**Consultation Response from KC,
Policy**
2020/93954 Land at, Lingards Road, Slaithwaite, Huddersfield, HD7 5HY
Erection of 42 dwellings and associated works
Date Responded:
Responding Officer: Amy Woodhead
Responding Ref:

This proposal is for the erection of 42 dwellings and associated works at – Land at, Lingards Road, Slaithwaite, Huddersfield, HD7 5HY.

Project HOUSING AT LINGARDS RD, SLAITHWAITE
 Client S. B. HOMES LTD
 Drawing P.O.S. DESIGNATIONS
 Scale NTS Date 10.10.22
 Dwg No 2019 572 62 Rev

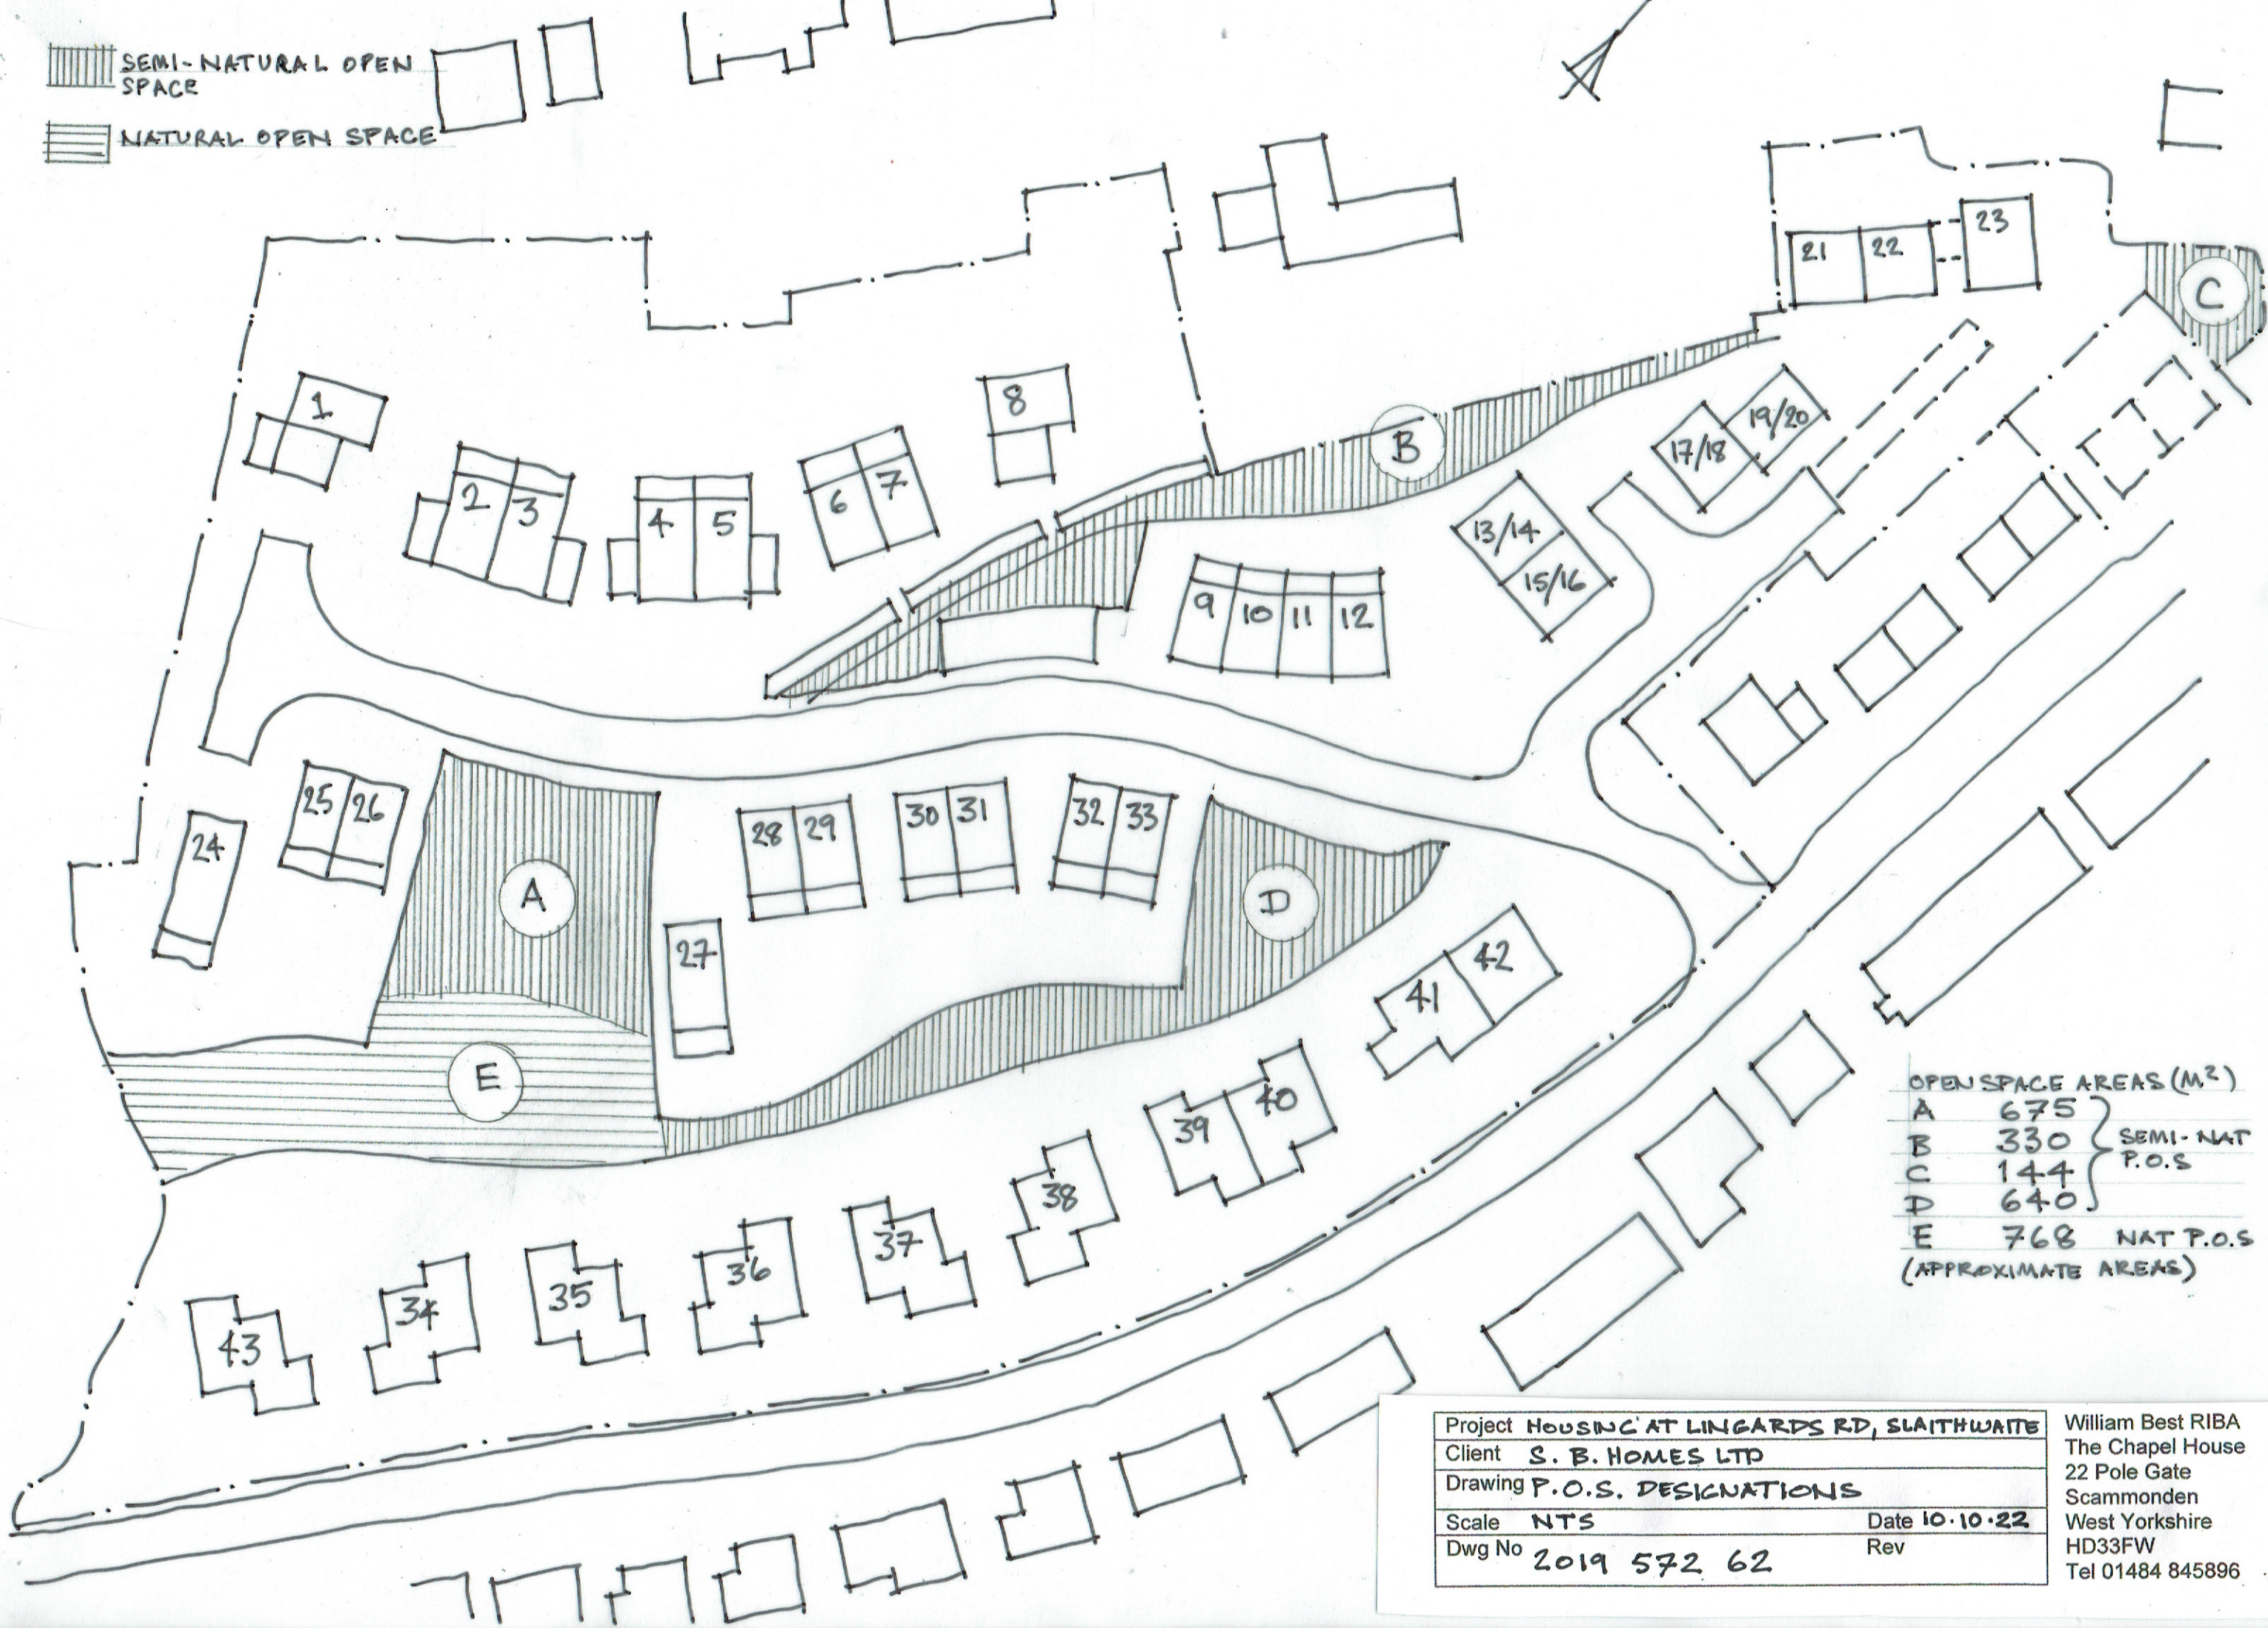
Since this development proposes 42 dwellings, new open space provision is required in accordance Local Plan Policy LP63 New Open Space and the Open Space SPD to meet the needs of the development. This is based on an assessment of the quantity, quality and accessibility of the existing open space within the area taking into account any deficiencies. This analysis will help determine the need for new on-site or off-site open space, enhancement of existing provision and/or a financial contribution and considers the need to provide for different types of open space. As such, the assessment in Appendix 1 indicates the open space requirement for a development of 42 dwellings in the Colne Valley ward. Further detailed information should be sought from the Council's Landscape team.

Project	Housing at Lingards Road, Slaithwaite			William Best RIBA
Client	SB Homes Ltd			The Chapel House
Drawing	SITE PLAN 3			22 Pole Gate
Scale	1:200	Date	13/10/2021	Scammonden
Dwg No	2019 572 52	Rev	E	West Yorkshire
				HD33FW
				Tel 01484 845896

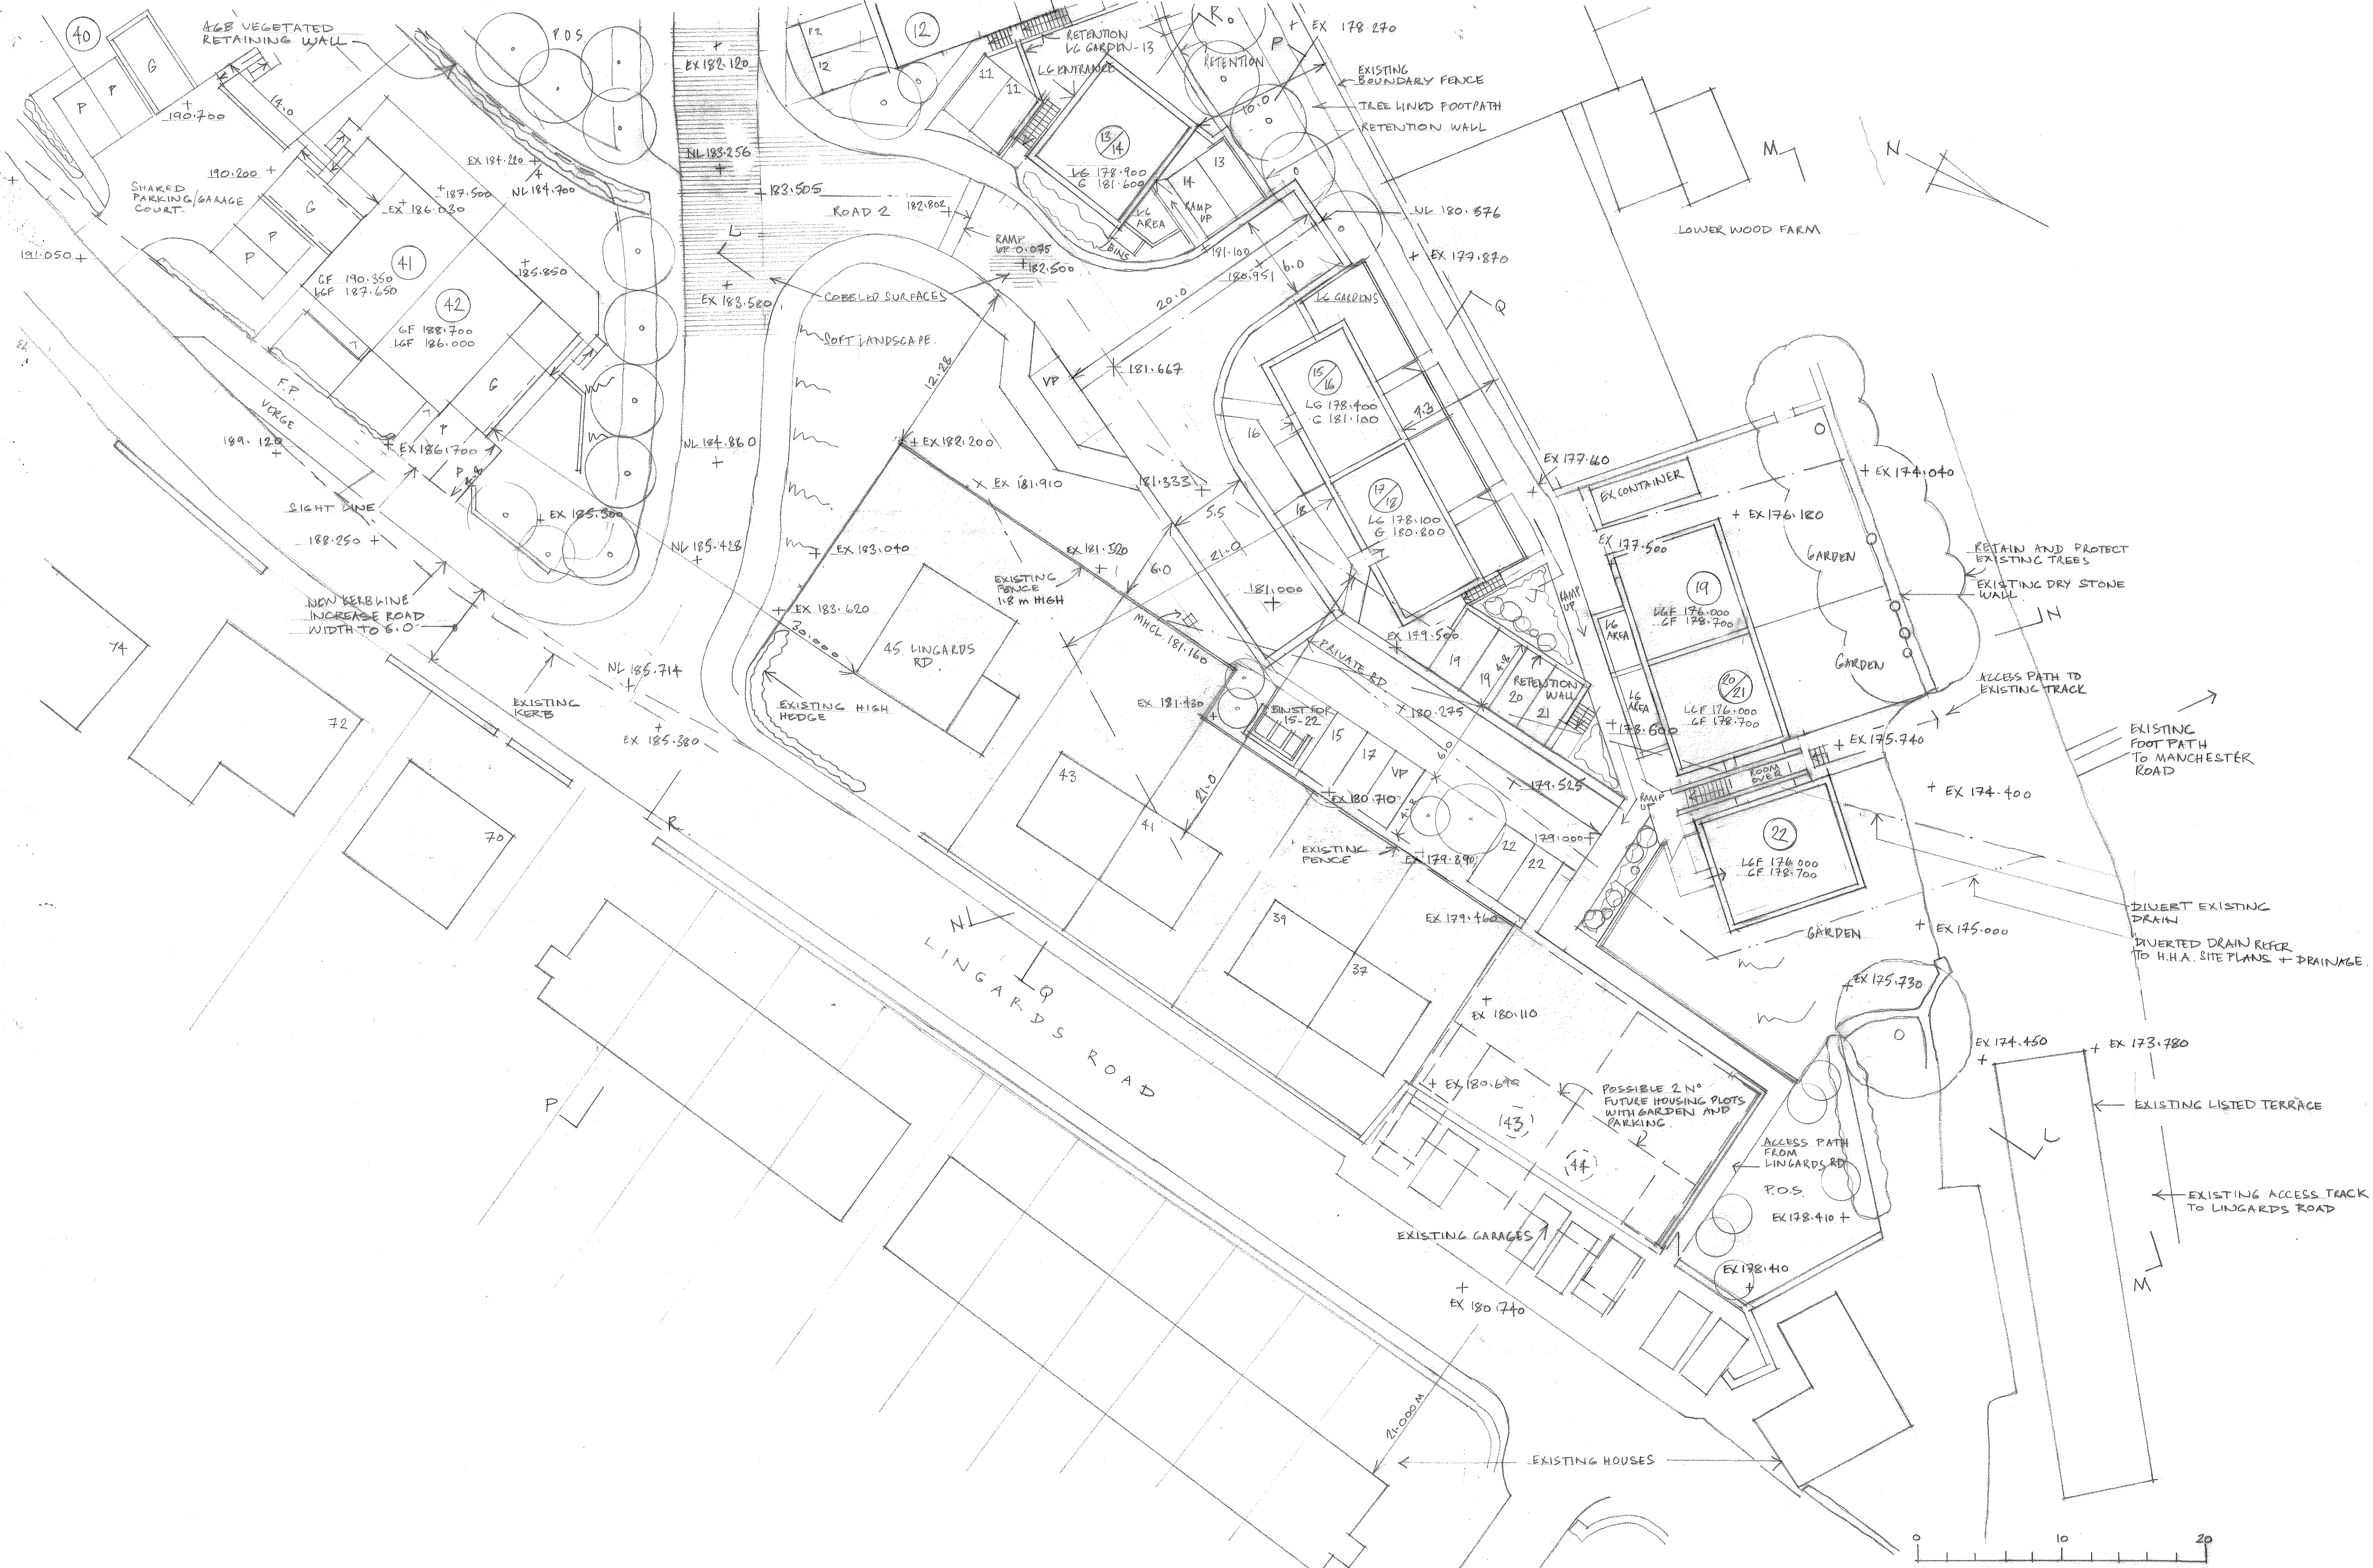
Part of the application site extends further west than the housing allocation boundary and encroaches into Green Belt land. It appears no housing development is proposed within the area of Green Belt – however the plans illustrate it is intended for there to be an underground attenuation tank, construction of a headwall and drainage works. Paragraph 150 of the NPPF states that certain forms of development are not inappropriate in the Green Belt provided they preserve its openness and do not conflict with the purposes of including land within it. Relevant to this proposal is criterion (b) of paragraph 150 – engineering operations. Consideration should be given to assess if the degree of development involved to drain the site is such that it constitutes an engineering operation. If it should be determined that the proposed development in the Green Belt does constitute an engineering operation, there is currently insufficient information to be able to accurately assess the proposal against paragraph 150(b), as due to the limited information, it remains unclear the extent to which the openness of the land will be impacted, or whether development will conflict with the purposes of including land within the Green Belt.

While the plans indicate a requirement for drainage works within the Green Belt, there is currently no information regarding the effect this work will have on the character of the existing field – in terms of resultant retaining walls relating to the headwall, or other engineered slopes or levelled platforms. If, as a result of the work, there is no material change – then this element may be compatible with NPPF paragraph 150(b), as there would be no impact on openness or conflict with the purposes of including land within the Green Belt.

If there would be a material impact such that the works would be deemed inappropriate in terms of paragraph 150(b), then alternative methods of draining the site may need to be explored. Inappropriate development is, by definition, harmful to the Green Belt and should not be approved except in very special circumstances. When considering the application, substantial weight should be given to any harm to the Green Belt. Very special circumstances will not exist unless the potential harm to the Green Belt by reason of inappropriateness, and any other harm resulting from the proposal, is clearly outweighed by other considerations.
